**Re: Penrith City Council Submission to Proposed Modification to Tox Free (formerly Chemsal) Waste Chemical Storage Facility (MP06\_0095 MOD3) at No. 40 Christie Street St Marys**

I refer to the Department's letter dated 30 May 2016 seeking Council's comments relating to MP06\_0095 MOD3 for Modifications to the consent for the Chemsal Waste Storage Facility at 40 Christie Street, St Marys (Lot 431 DP 854814).

Figure 3: Current Site Layout and Proposed AAN Processing Locations

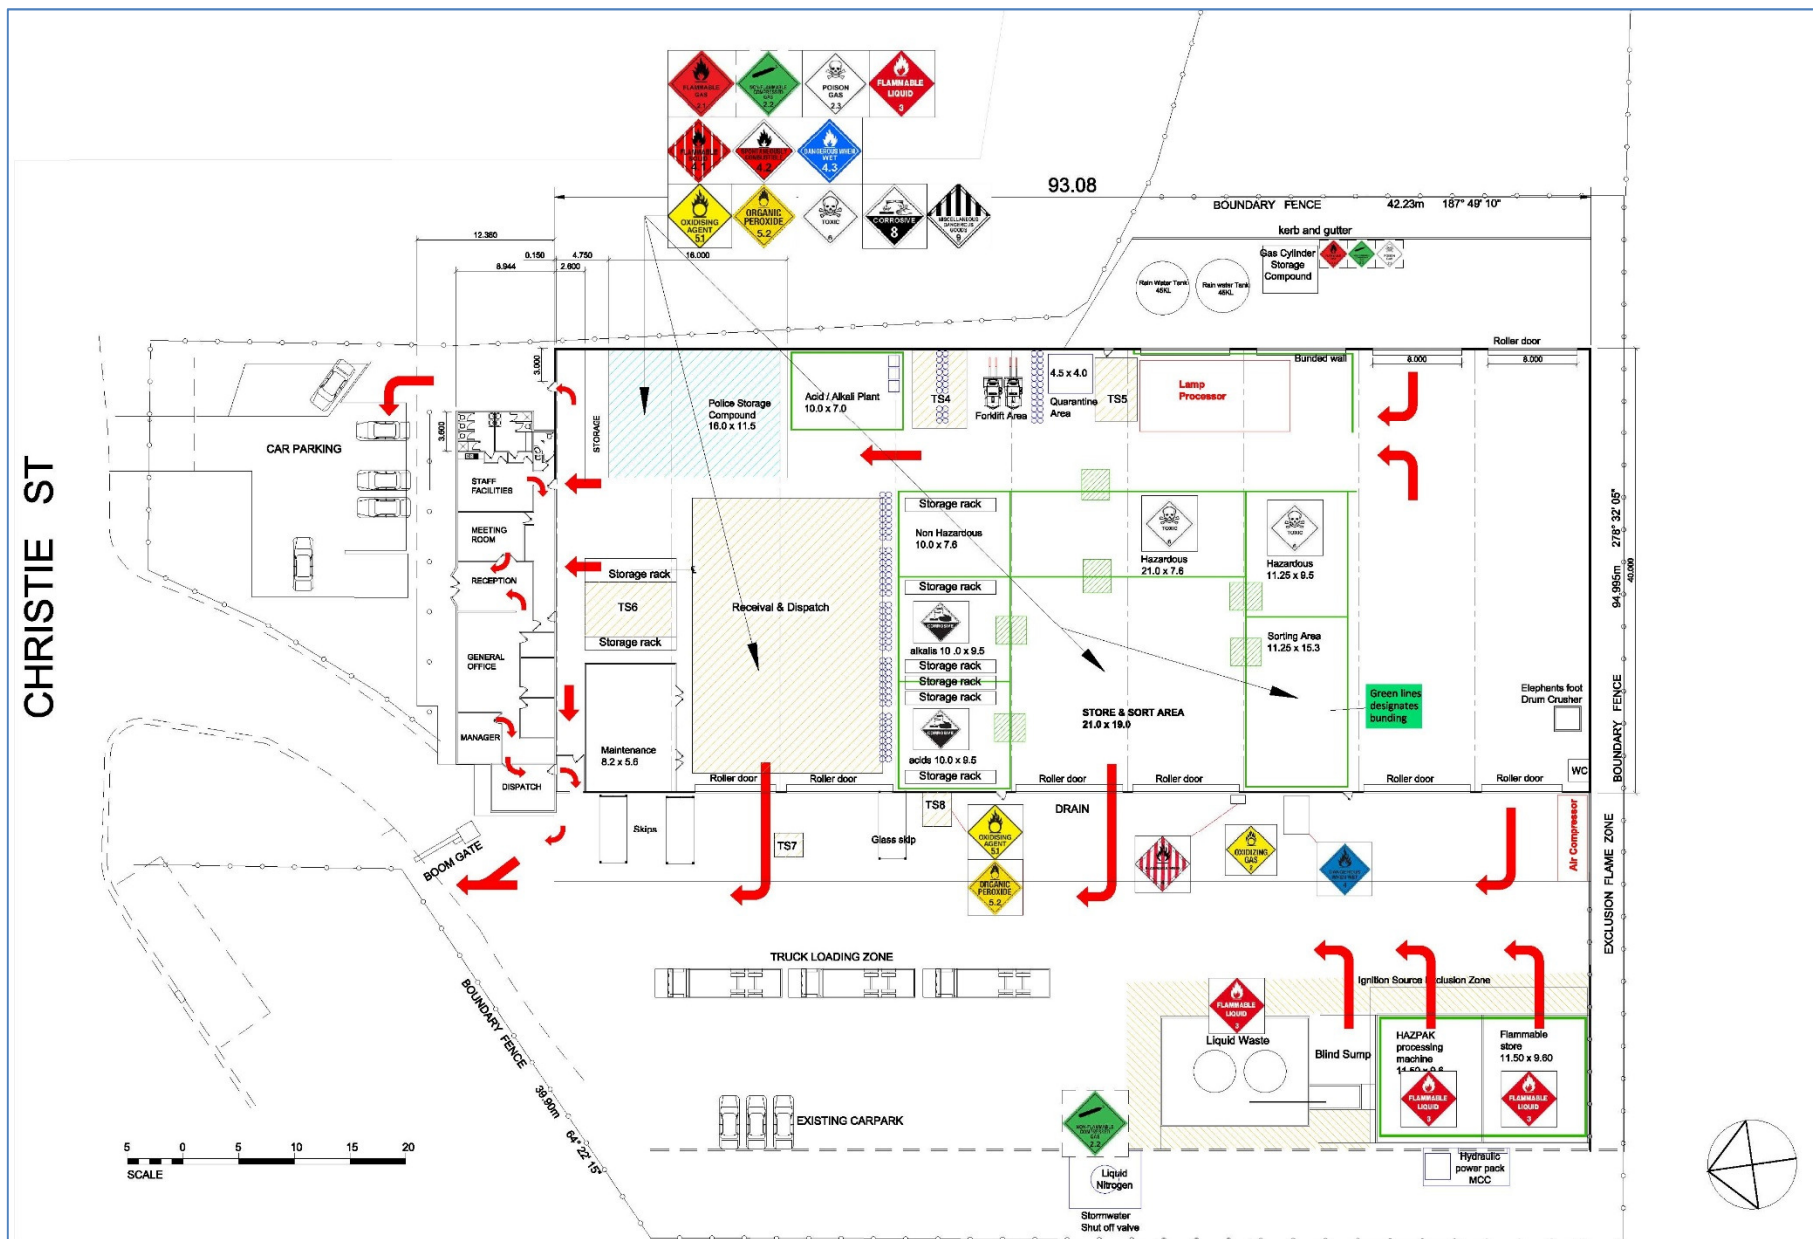
- Whilst the exact location of the AAN process has not been established (the application identifies three potential locations), the proposed modification will occur within the existing warehouse within bunded areas. The Department and NSW EPA should ensure that the existing (and proposed) bunding is compatible with the liquids and chemicals, both singularly and in combination, to ensure that the integrity of the bunding material shall not be adversely impacted by the nature of the chemicals present on site.
